Please ask for: Mrs D Johnson
Email: daun.johnson@arun.gov.uk
Telephone: 01903 737762
Our Ref: LU/88/20/PL
Your Ref:
Date: 3rd April 2020

Application for Planning Permission

Development: Installation of breathable membrane & battens to the render & overlaid the whole of the southwest facade with grey composite cladding planks. This application may affect the setting of a listed building & may affect the character & appearance of the Littlehampton River Road Conservation Area. This application is not CIL Liable.

Location: Lifeboat Station Surrey Street Littlehampton BN17 5BL

Littlehampton Lifeboat Station

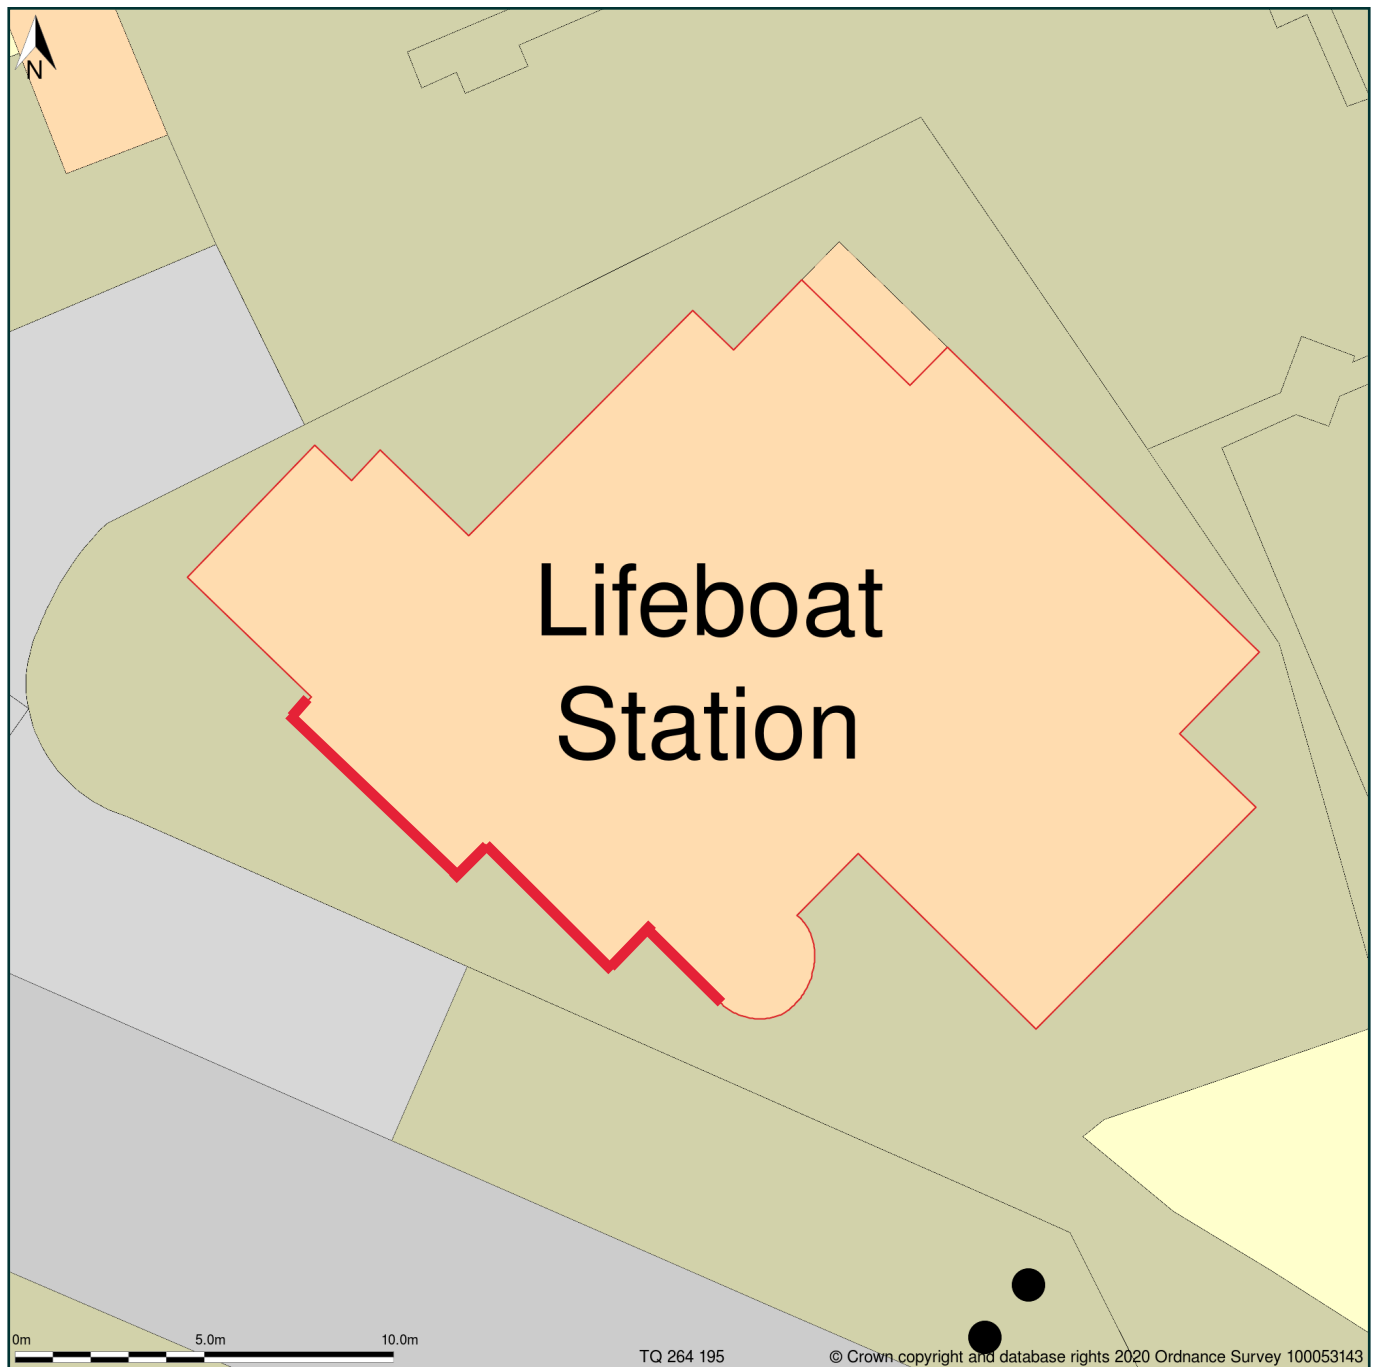
On the block plan, please clearly indicate the elevation of the proposed cladding.
